From: MarkHobbs [REDACTED]
Sent: 08 November 2021 10:18
To: Paul Cann
Cc: Glynn Curtis; Sarah Burrow
Subject: RE: Little Sefter Extension, Pagham, Bognor Regis - OWC Application
Attachments: Barfoot - Sefter Barn FC2846.02E SW Drainage.pdf; Barfoot - Sefter Barn FC2846.03E Ext Levels & CF.pdf

From: Paul Cann <Paul.Cann@arun.gov.uk>
Sent: 28 October 2021 12:33
To: MarkHobbs [REDACTED]
Cc: Glynn Curtis [REDACTED] Sarah Burrow <Sarah.Burrow@arun.gov.uk>
Subject: RE: Little Sefter Extension, Pagham, Bognor Regis - OWC Application

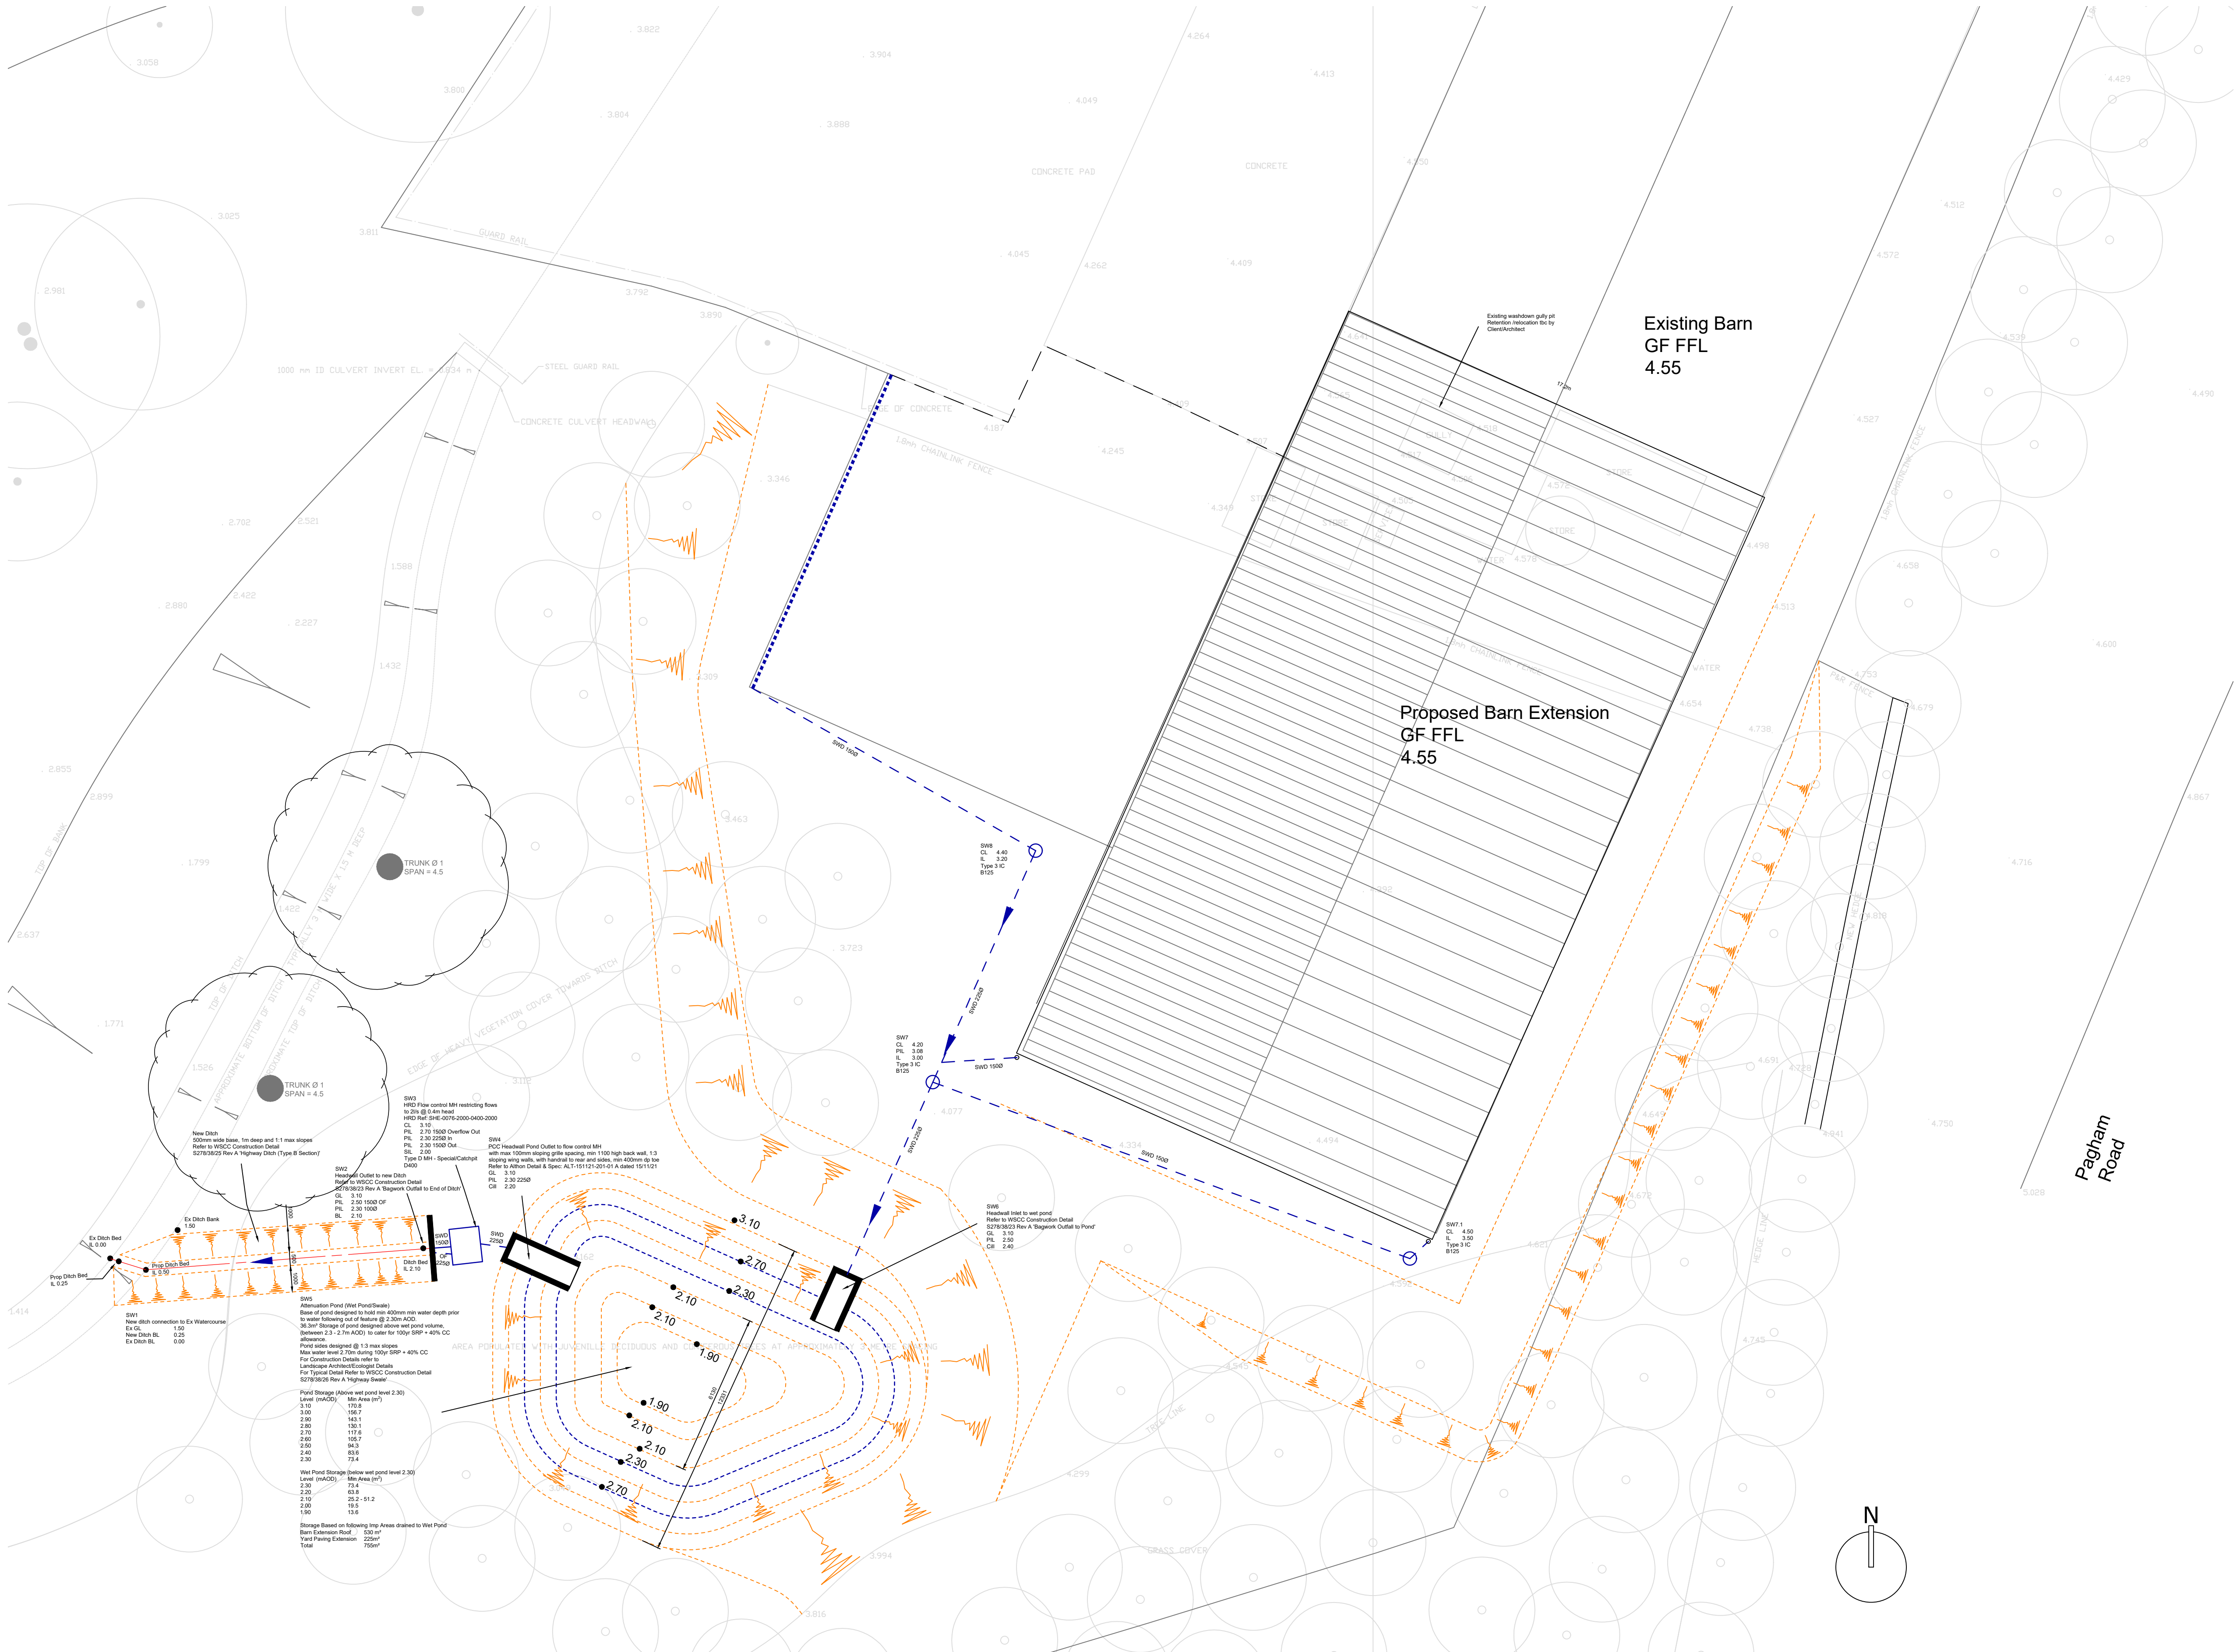
Pond Outfall headwall will have trash screen.
Flow control Mh will have overflow.

Visual indicator will be high water level in pond and water flowing from overflow pipe into discharge ditch.

The discharge rate would be assessed/agreed as part of the DOC application associated with P/38/21/PL (likely to be looked at by others). However, with the landscape plan in mind, I would suggest restricting to 2 l/s (normal requirement is to restrict to QBAR based upon the positively drained area) but incorporate measures to reduce the risk of blockage/provide visual indicators of a blockage issue ie. specify suitable sloped face/bar spacings (45 degree) trash screen and a visible overflow arrangement ie. spillway, so issues can be easily seen. This can all be tied up in a suitable management & maintenance manual, as regular maintenance also helps reduce the risk.

Updated drawings with discharge restricted to 2l/s as requested 🌐 plus picking up your previous comments.
